# PONDEROSA AT LORSON RANCH FILING 3

## A PLANNED UNIT DEVELOPMENT AND PRELIMINARY PLAN

REV #	REVISIONS	DATE
1	1st Response to County Comments	1.8.2020
2		
3		
4		
5		
6

STREET DETAILS  
**P4** of 10

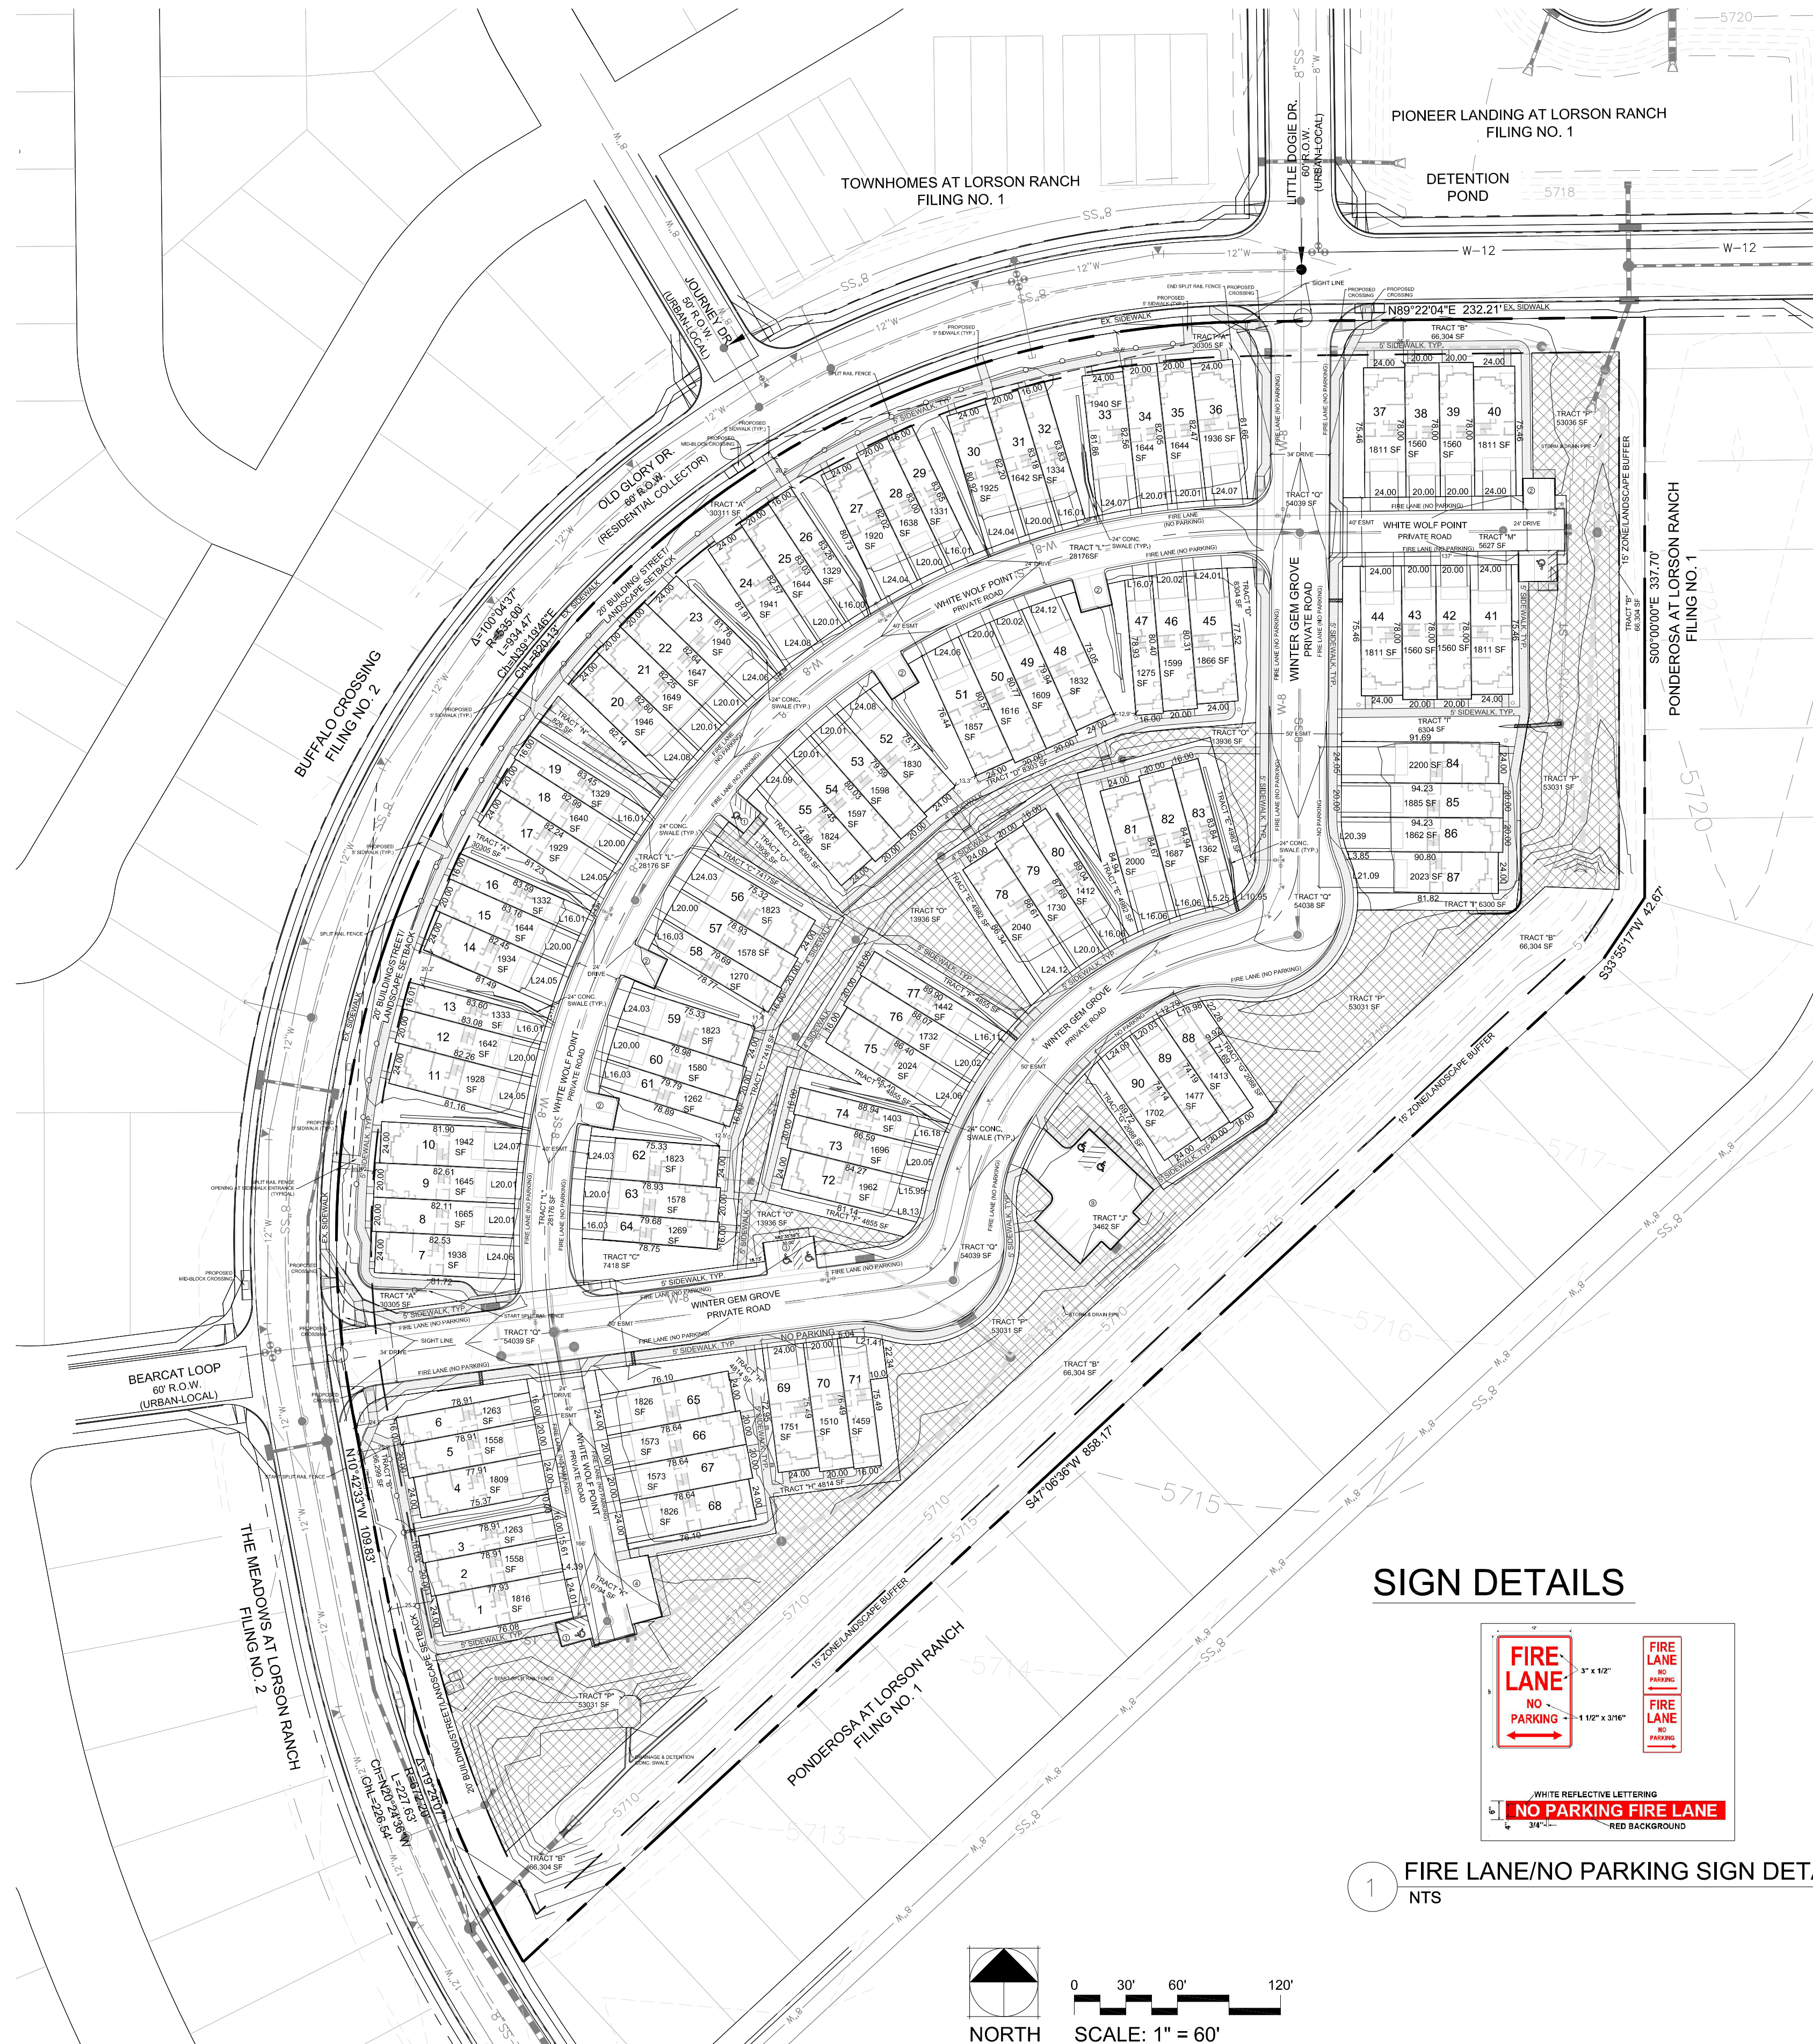
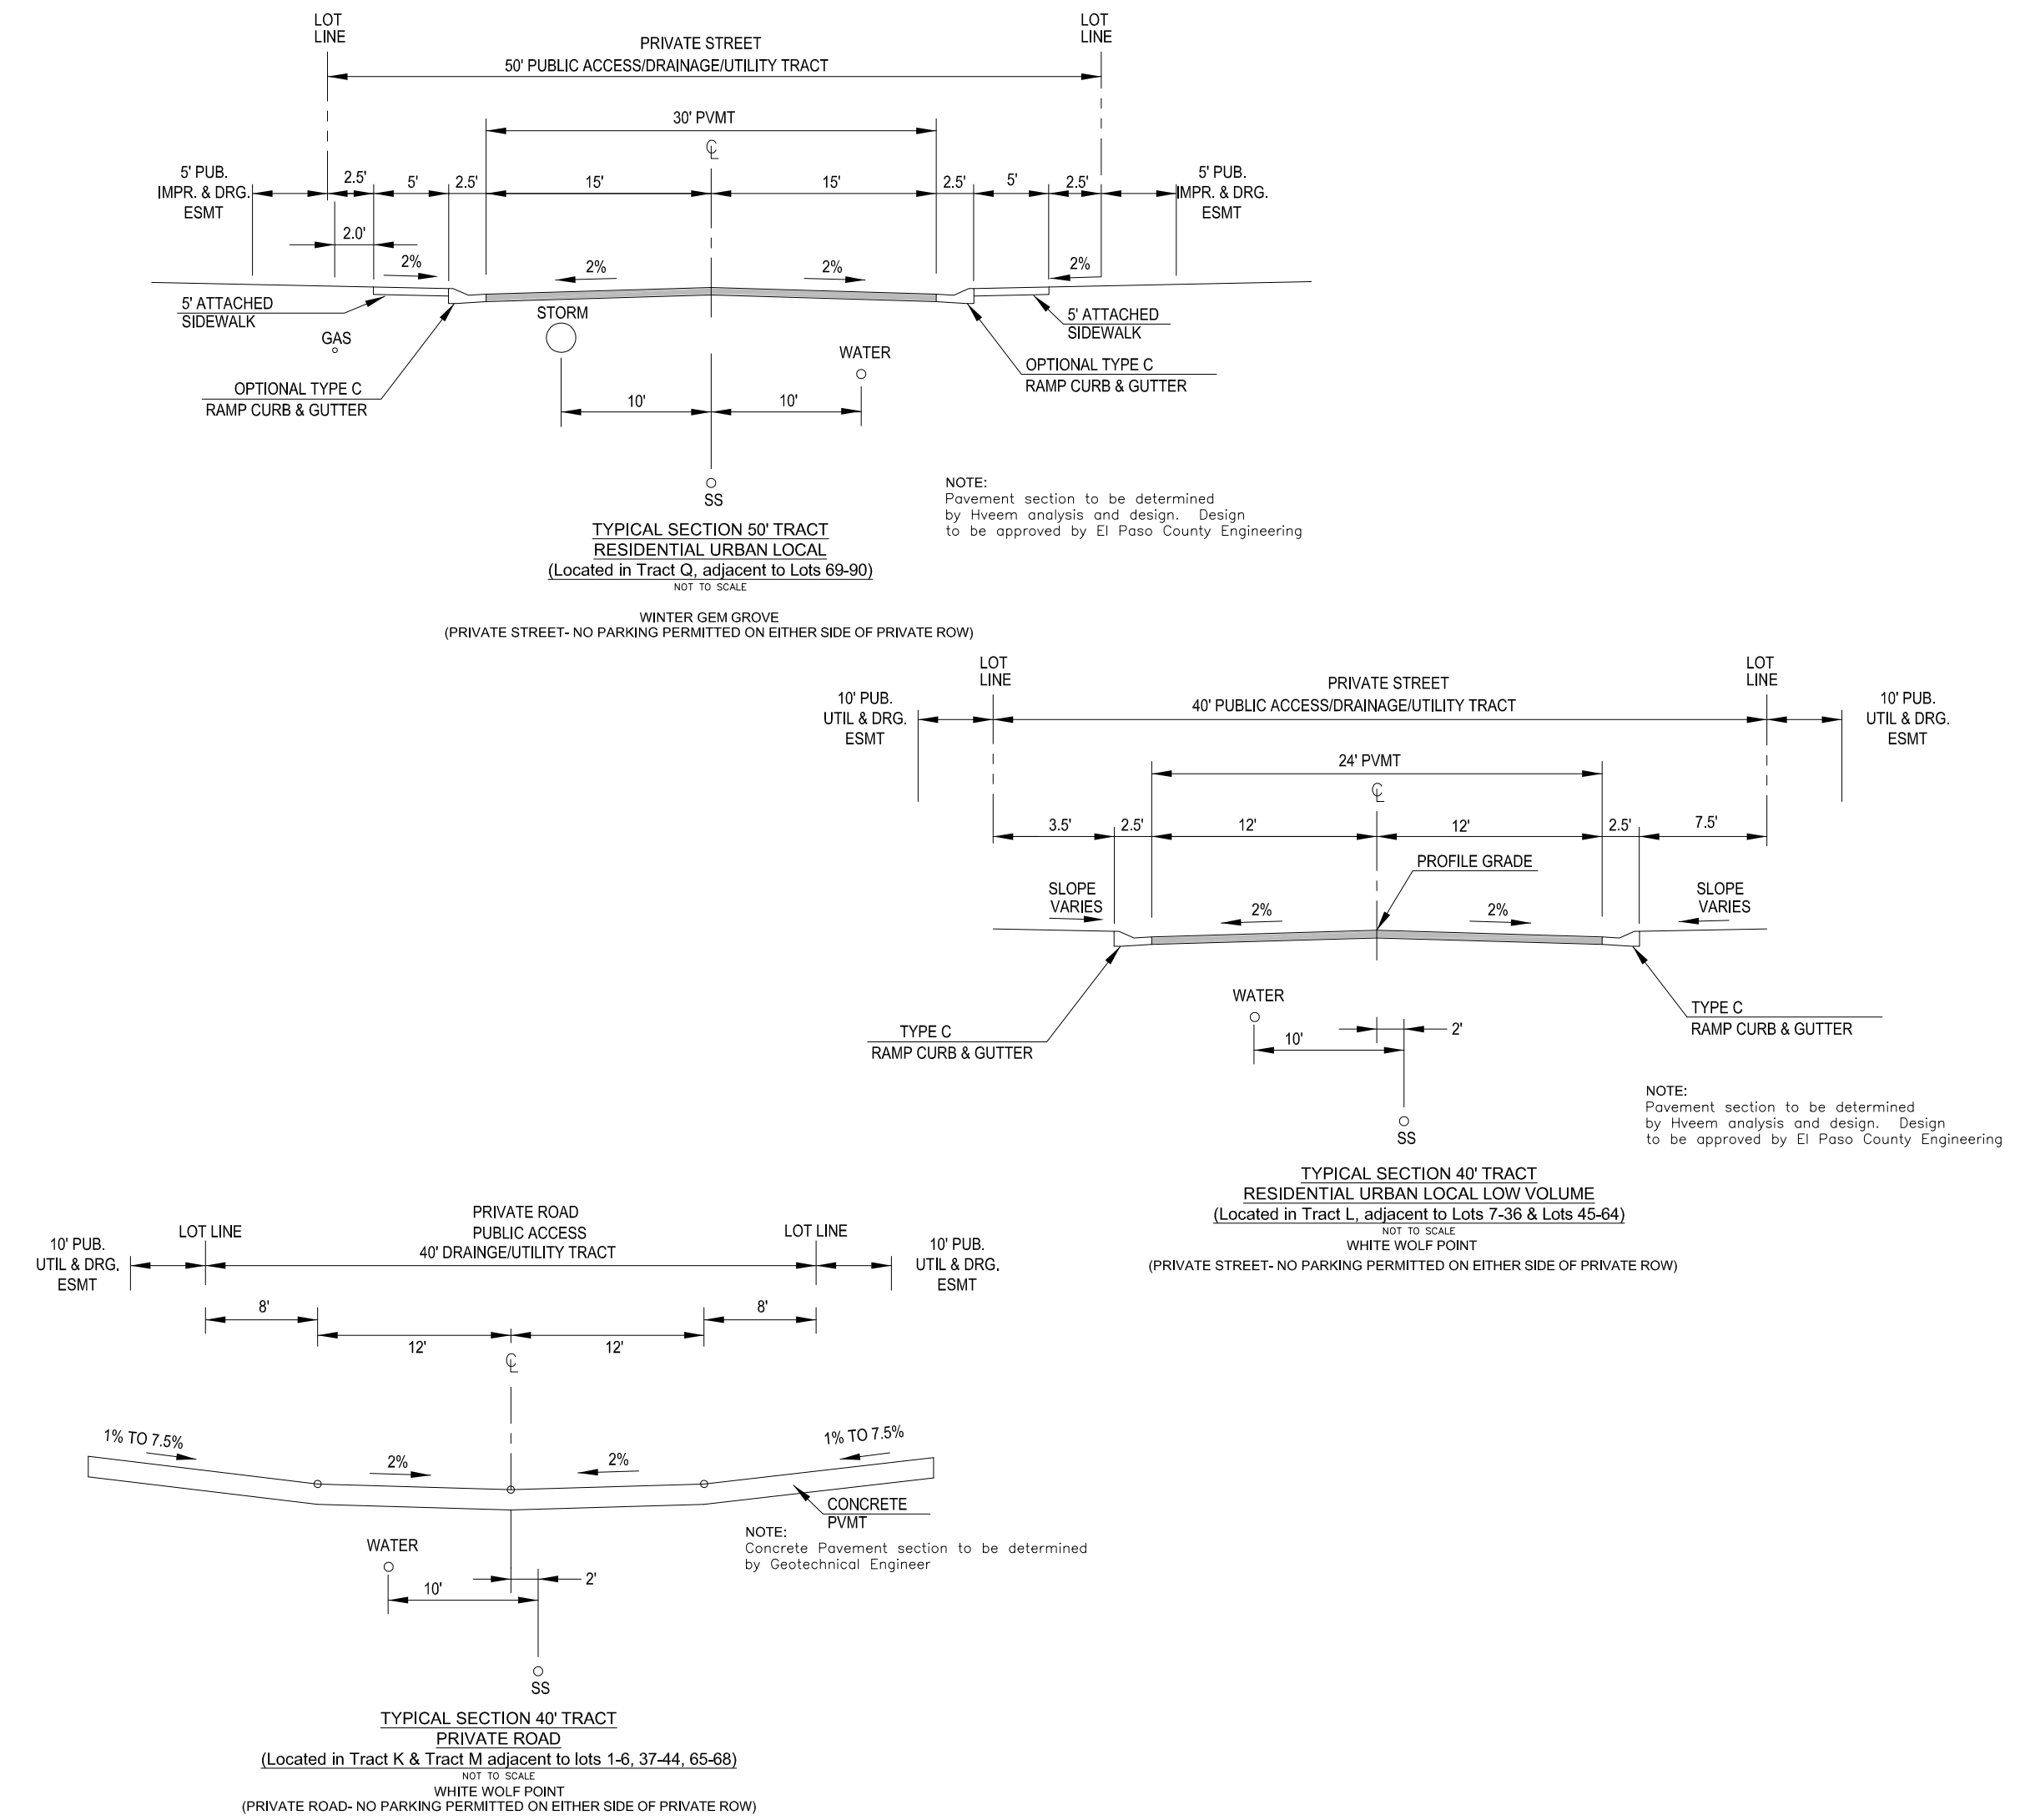
VERIFY LANDSCAPE ALONG EXISTING OLD GLORY IS NOT TO BE MAINTAINED BY DISTRICT. DISTRICT WOULD HOLD LICENSE AGREEMENT AND SHOULD BE MAINTENANCE HOLDER. CHANGE ON PUD TRACT TABLE AND NOTE(S)

if parking is permitted on both sides of private road the drive isle is reduced to 14' that is tight. Parking on one side of roadway only and signed as such may be appropriate.

Label road names

label drainage and detention facilities
